**Proposed Development: HyNet Carbon Dioxide Pipeline**  
**Planning Inspectorate Reference: EN070007**  
**Applicant: Liverpool Bay CCS Ltd**

Written Representation by Nicky Crosby  
Registration ID 20037840

**Aston Hill - Block Valve Station (BVS) Drainage Layout**

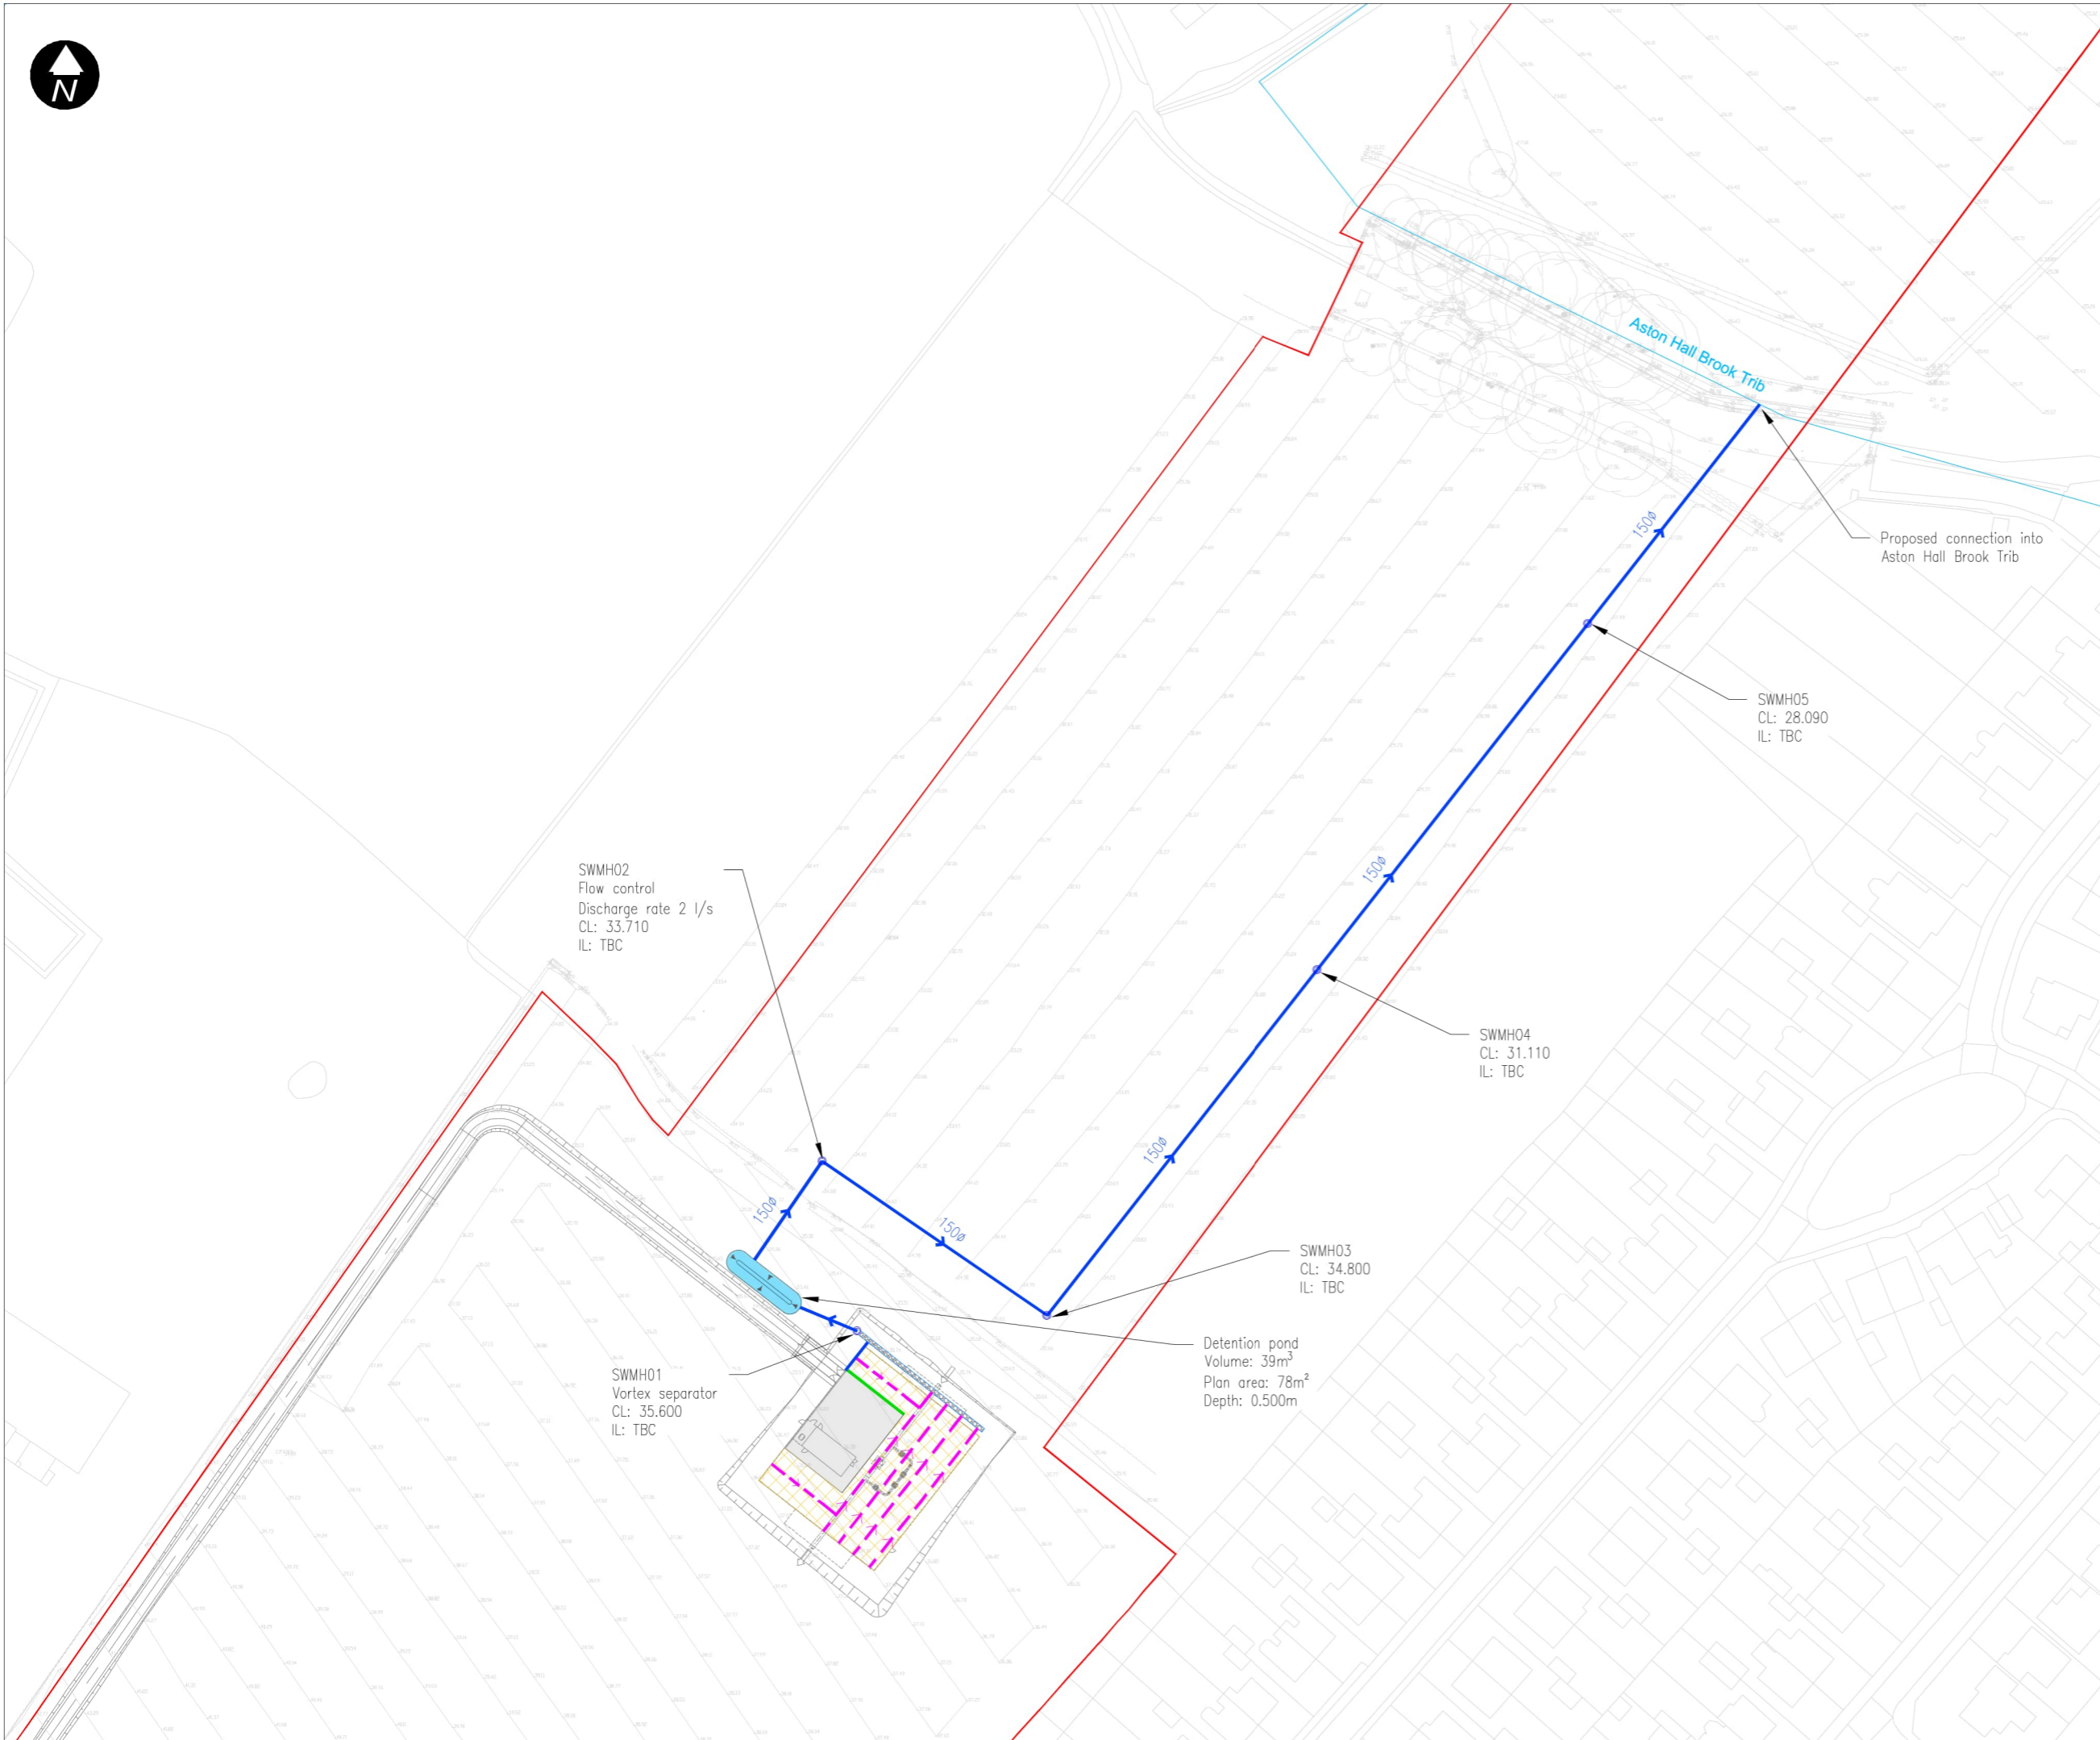
- 4.3. The maps show that substantial sections of the pipeline, as well as Aston Hill BVS and the Point of Ayr terminal, will be below annual flood levels by 2050. Alston Hill BVS (Diagram EN070007-D.2.8-EL-Sheet 3, D.2.8 updated Mar 23), does

not appear to be mentioned in the flood risk assessment with the (D.6.3.18.4). The Point of Ayr terminal has been scoped out of this assessment, but is presumably essential for pipeline operation.

Although the applicant has quoted climate related sea level rises in the Flood Risk Assessment, this does not appear to have been discussed in meetings with the Environment Agency or Natural Resource Wales. The applicant has not indicated impact or mitigation. What arrangements has the applicant made for maintenance and security of the pipeline when under water?
